NSW RURAL FIRE SERVICE

Your reference: SSD 5300 EIS
Our reference: S14/0039

26 November 2014

Kembla Grange Waste Resource Recovery Facility 50 Wyllie Road Kembla Grange

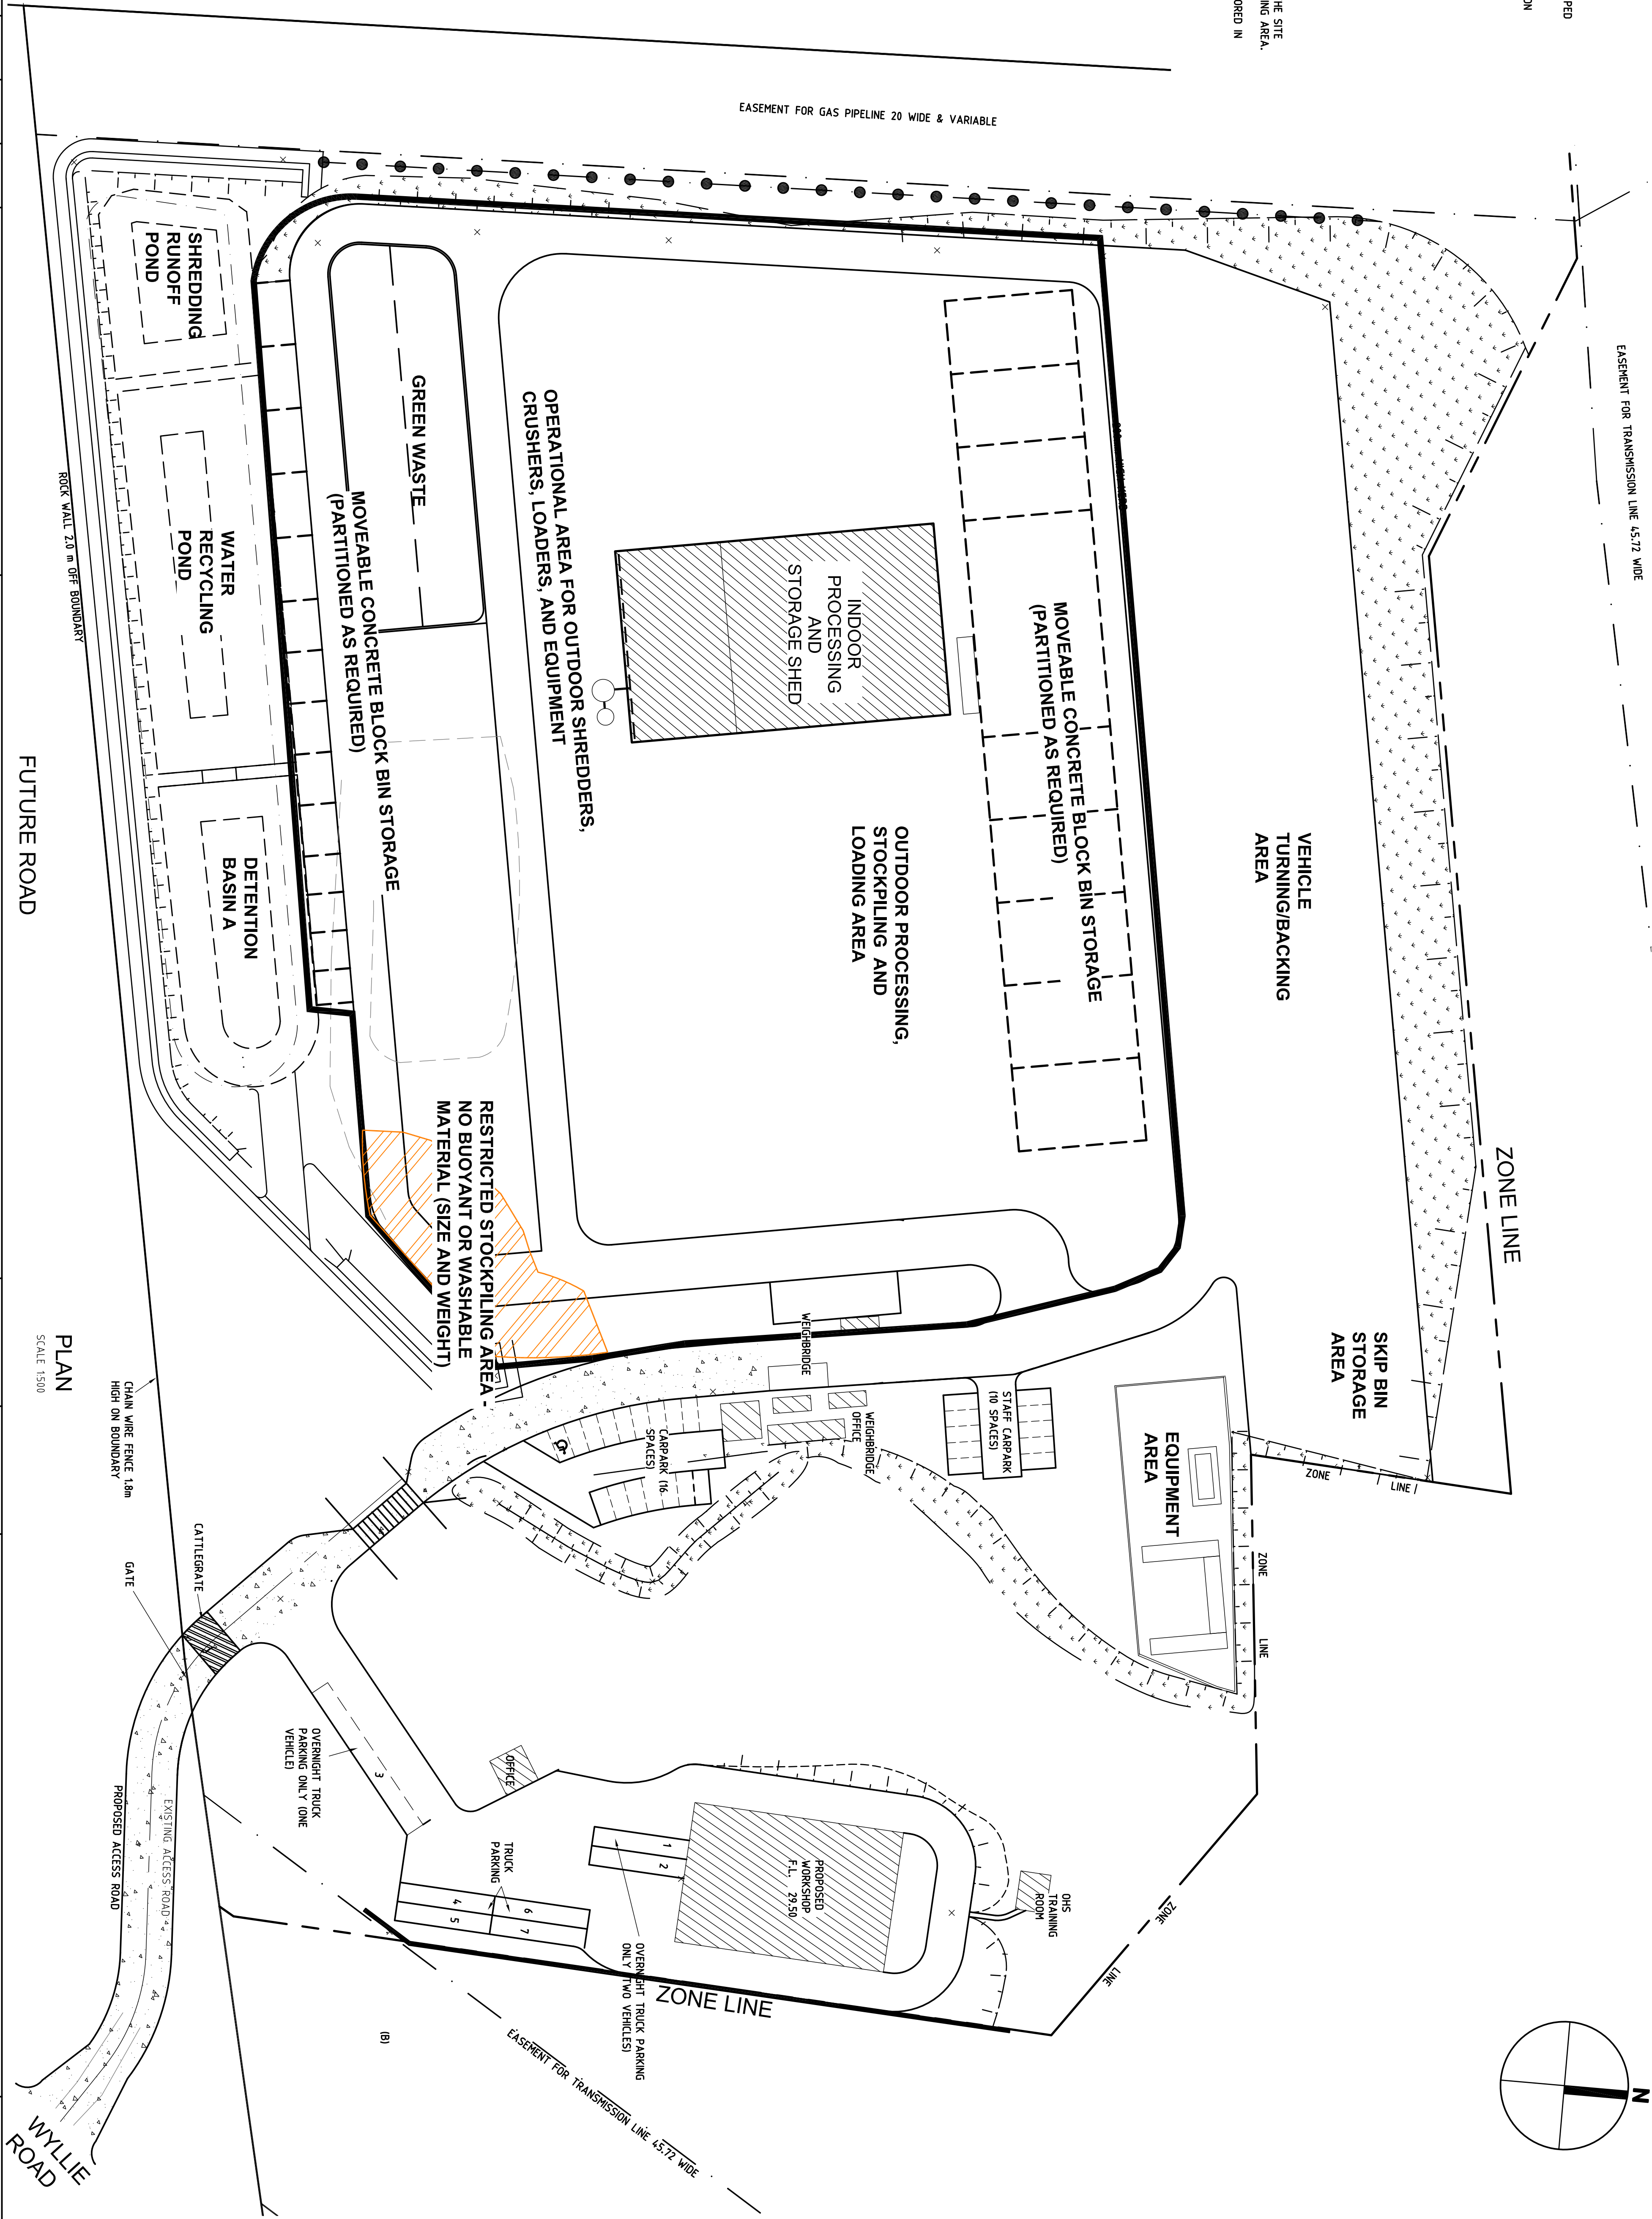
1. At the commencement of works and in perpetuity the property shall be managed as an inner protection area (IPA) as outlined within section 4.1.3 and Appendix 5 of 'Planning for Bush Fire Protection 2006' and the NSW Rural Fire Service's document 'Standards for asset protection zones' as follows:
 - for 100m north and east of the outdoor processing and stockpiling area.
 - west and south of the outdoor processing and stockpiling area to the property boundary.
 - an additional 19m east of the proposed workshop building.

Note: The asset protection zone includes all of the riparian area between the processing and stockpiling area and the workshop area.
